Our Ref: EN0110001

Date: 22 September 2025

### **Application by Keadby Next Generation Limited for an order granting development consent for The Keadby Next Generation Power Station Project**

#### **Advice following issue of decision to accept the application for examination**

60721867

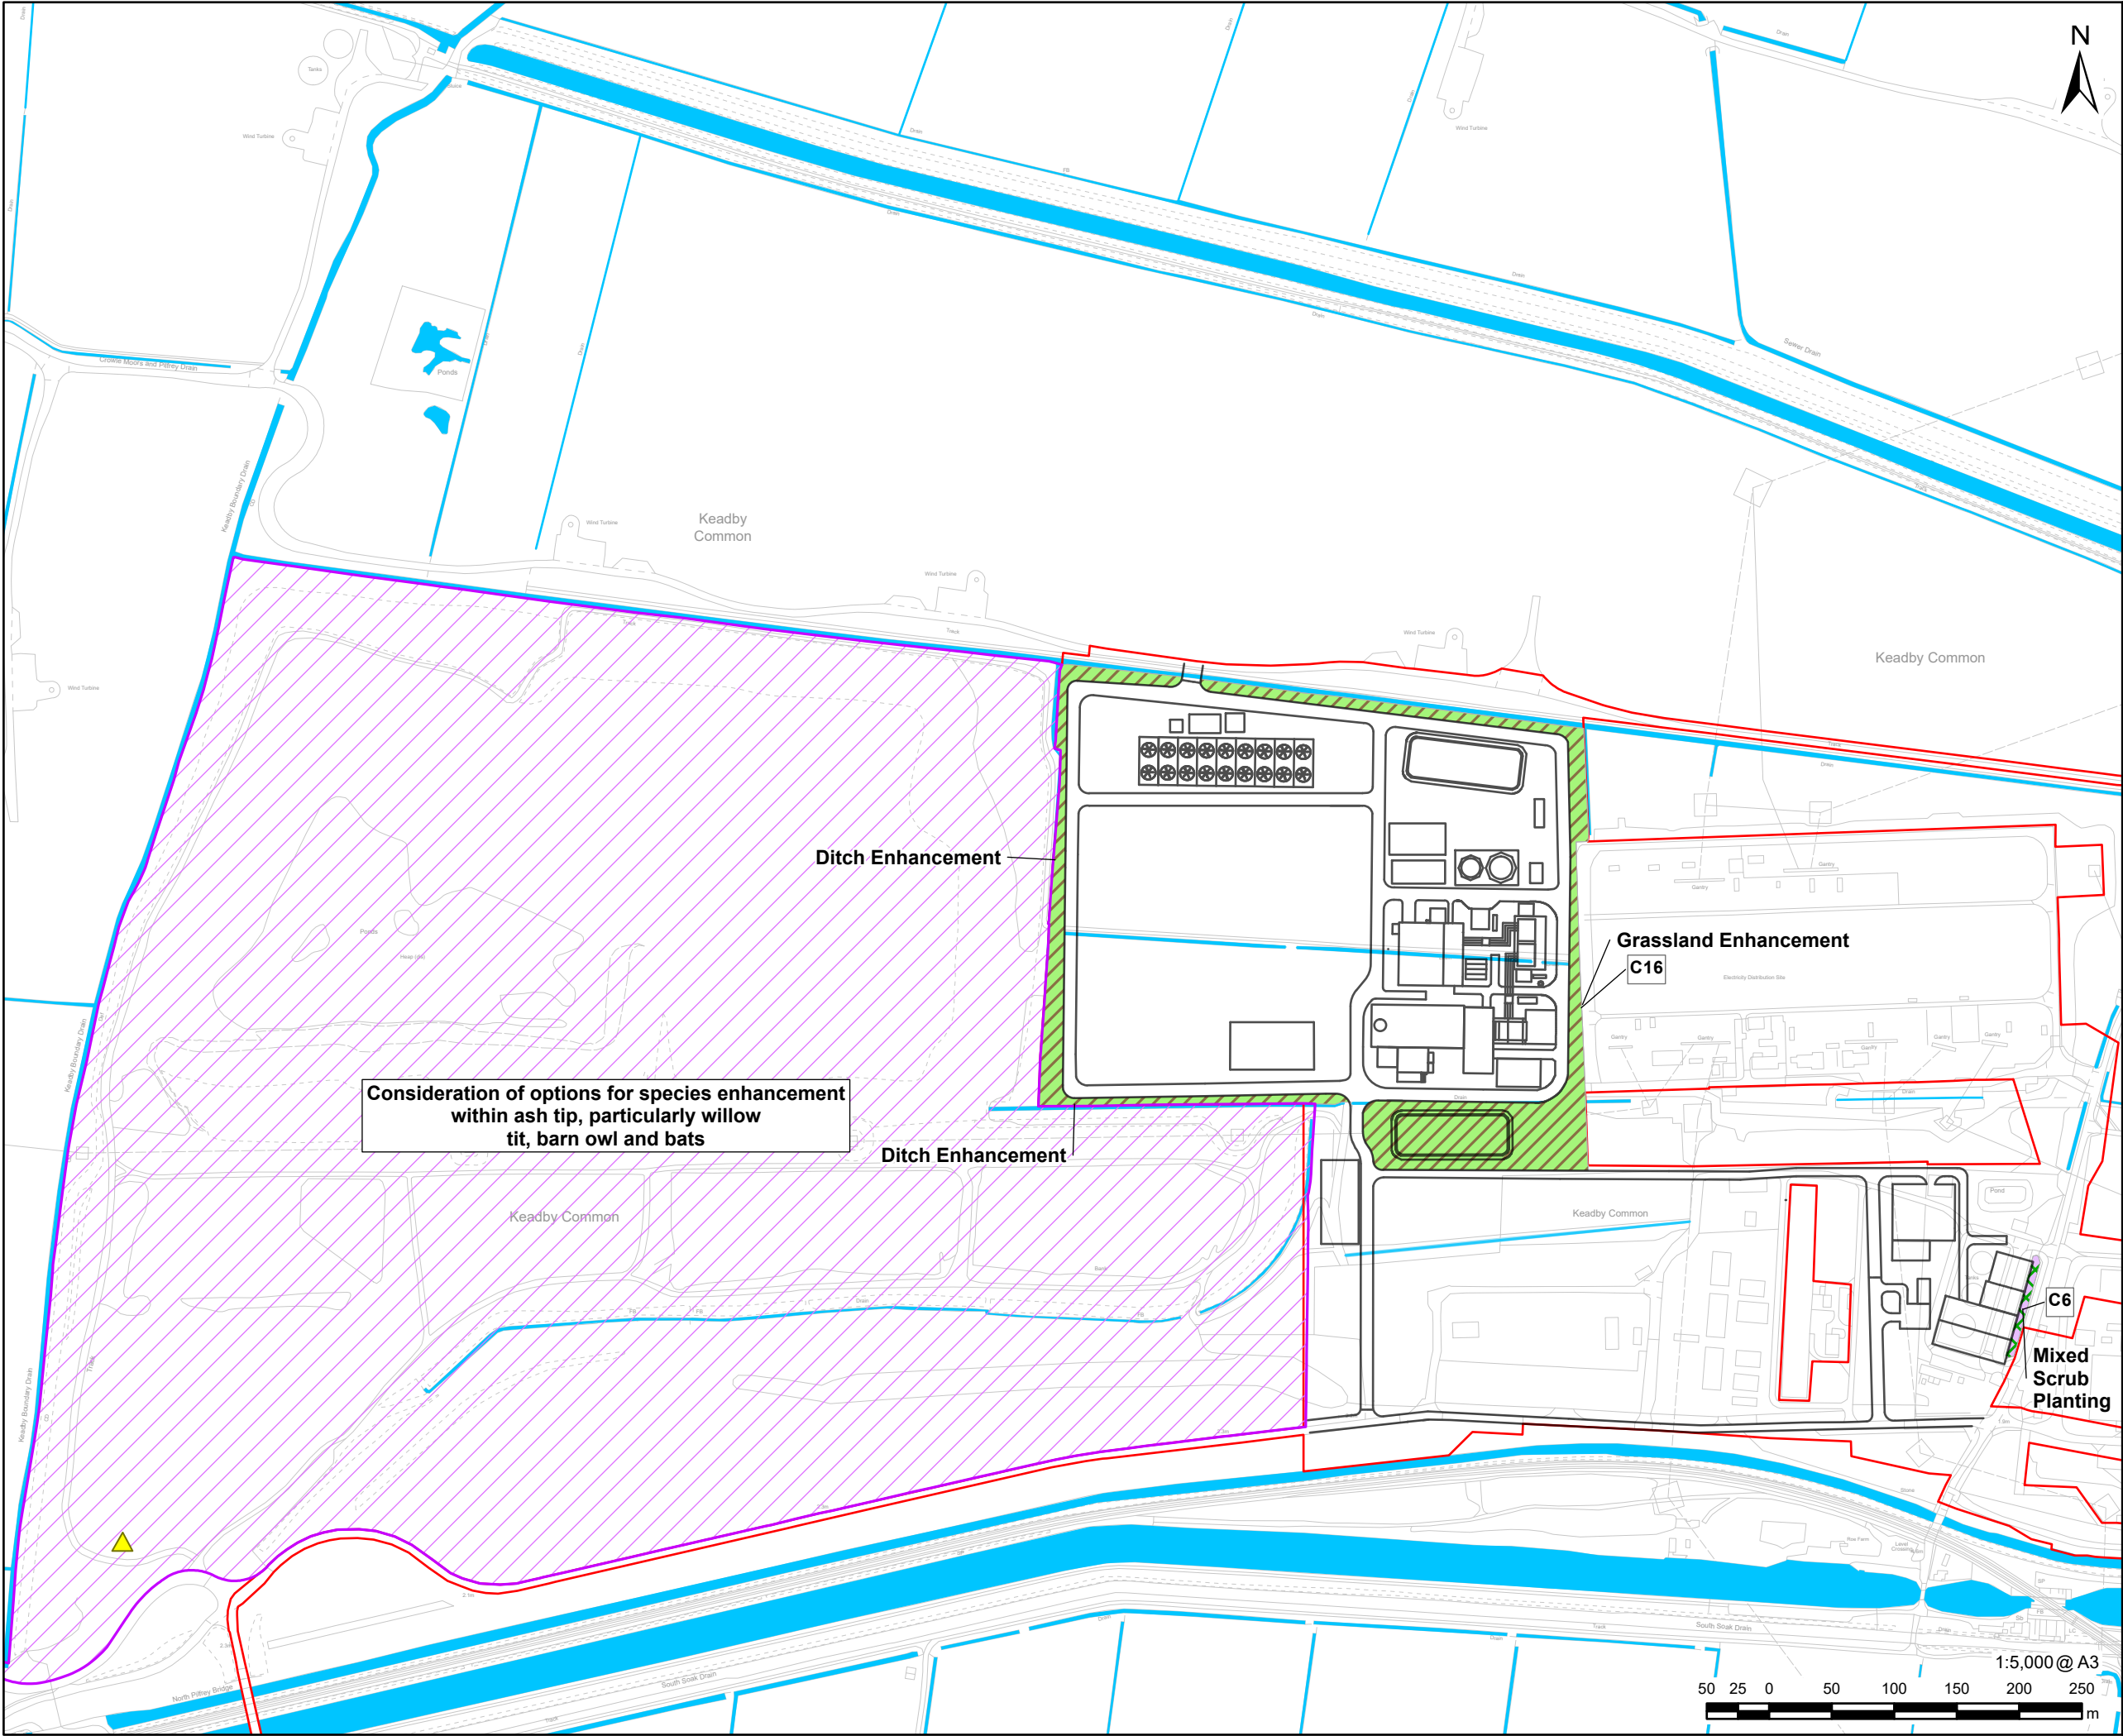
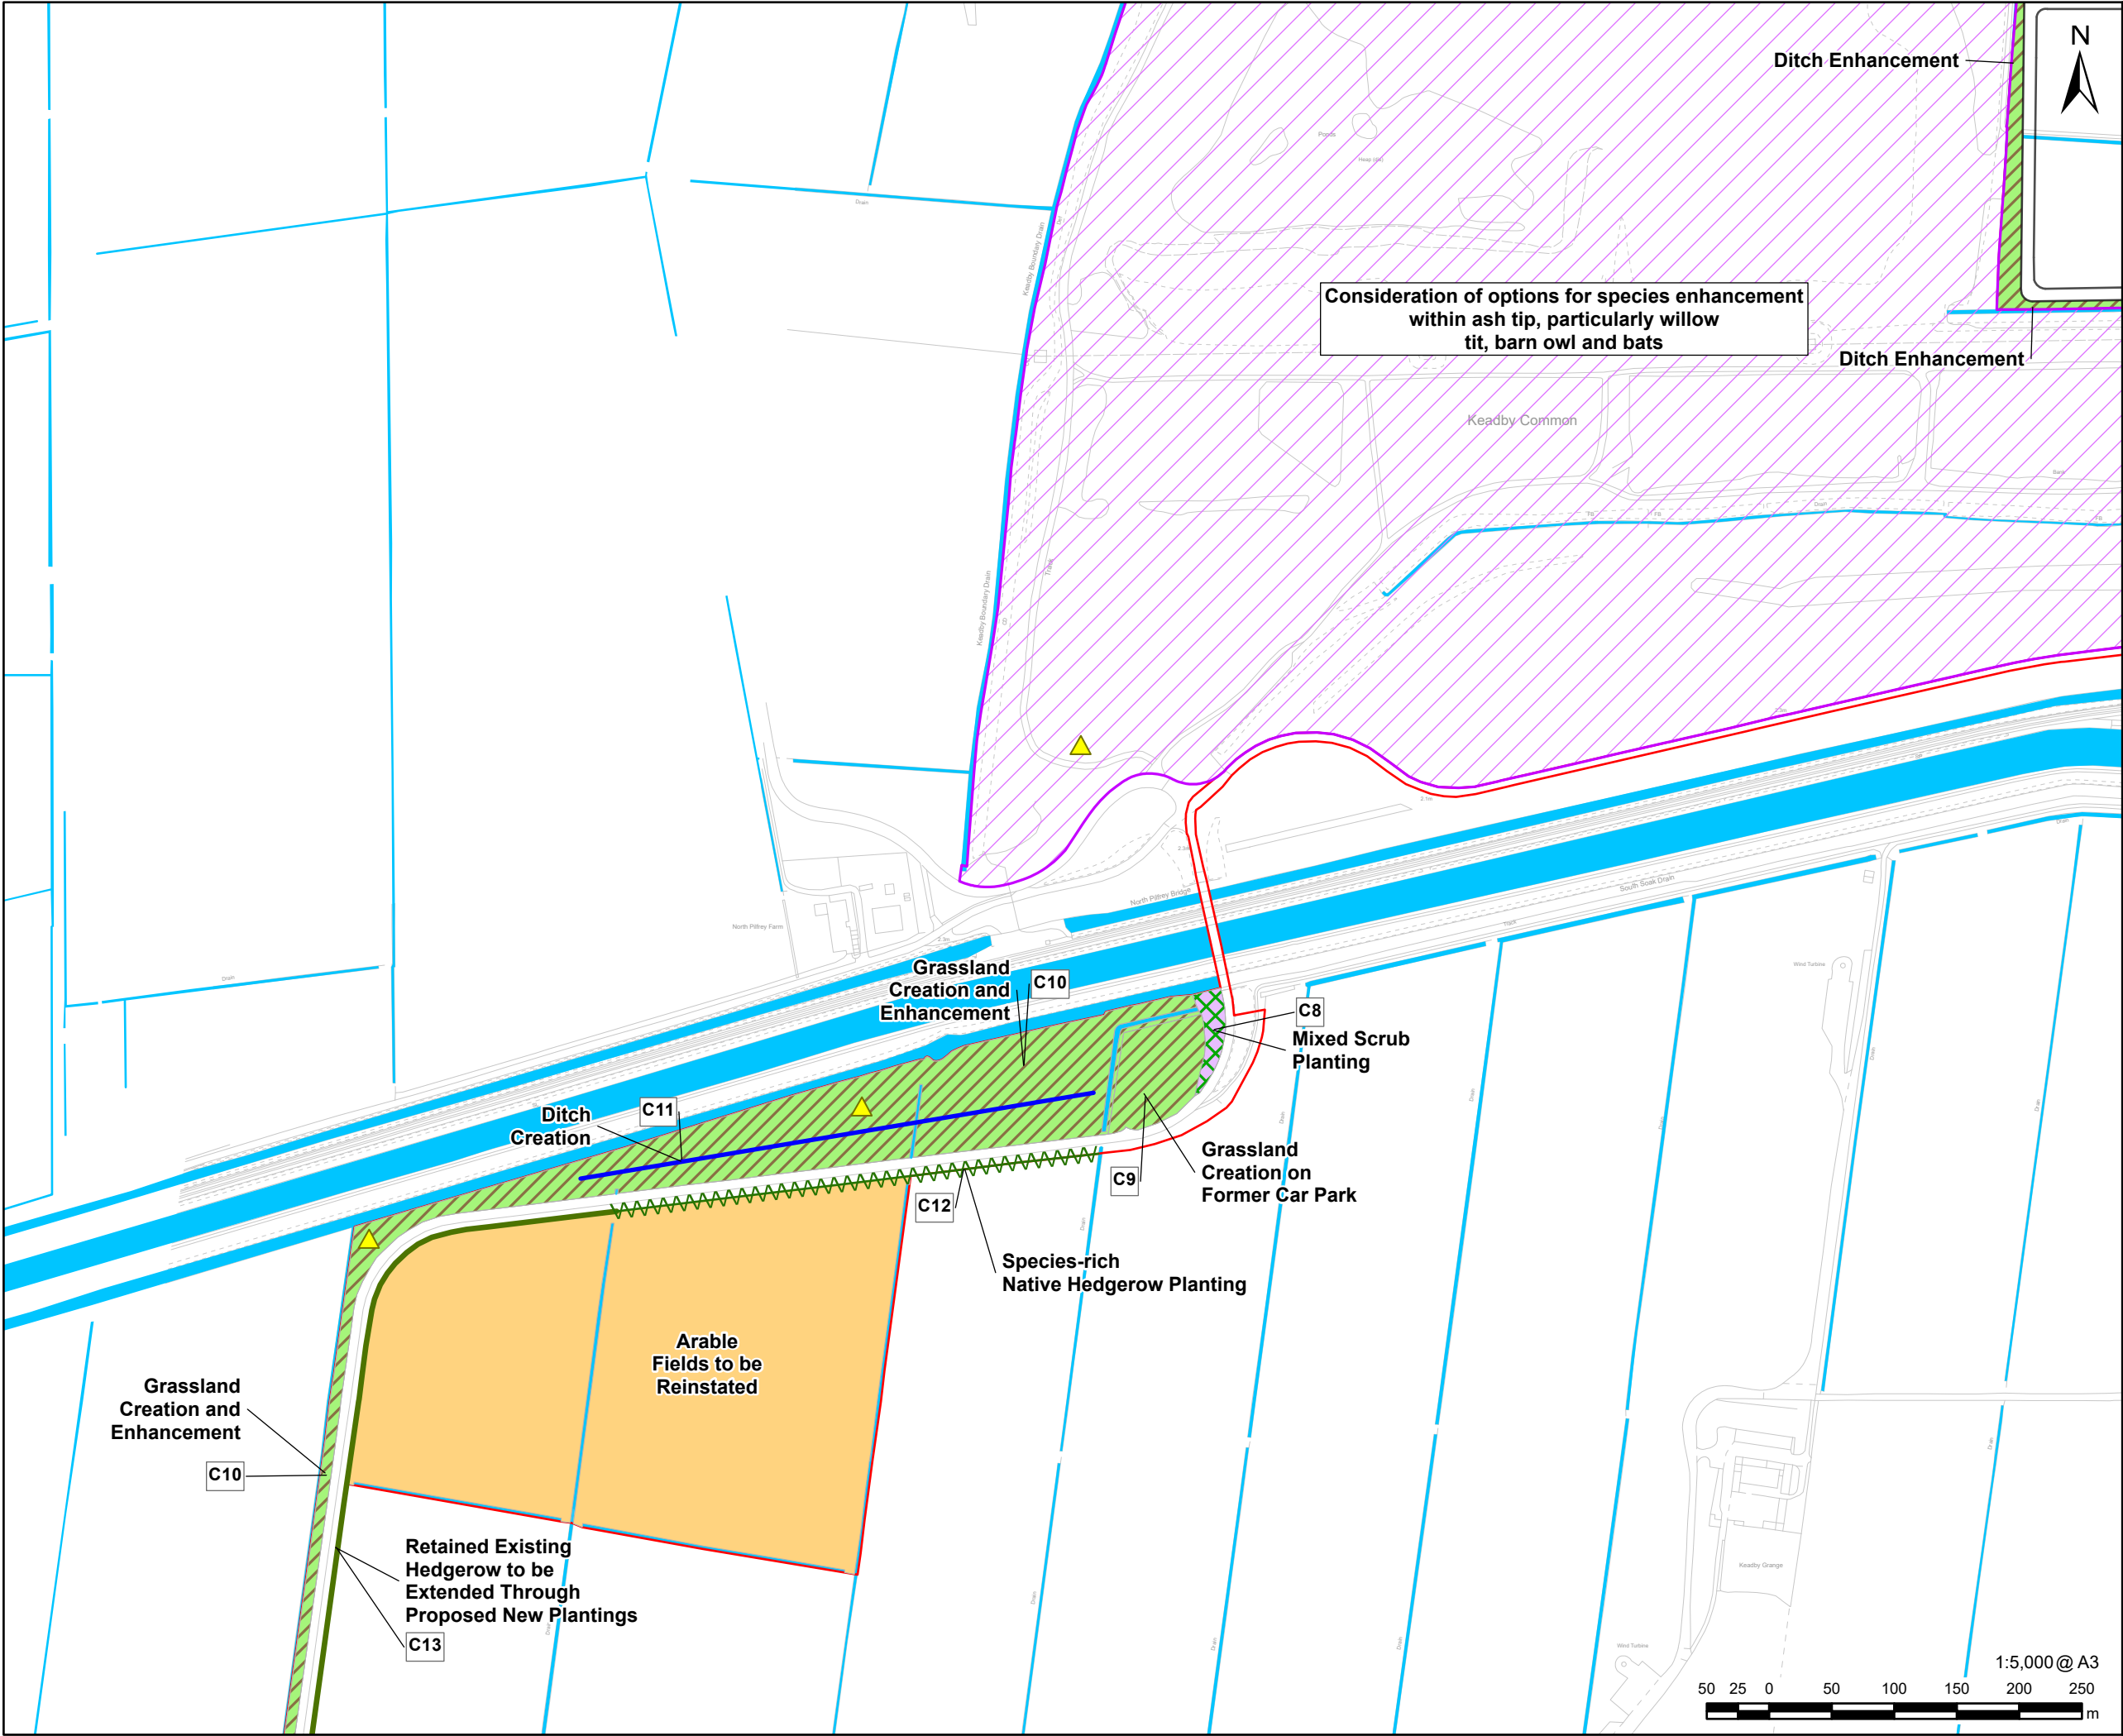
### **Indicative Landscape and Biodiversity Plan (Doc 2.18)**

The plan is missing a key plan. Although it doesn't affect the ability to view or understand the plans, the applicant is advised to amend this. It would be helpful if this could be also be provided at a larger scale.
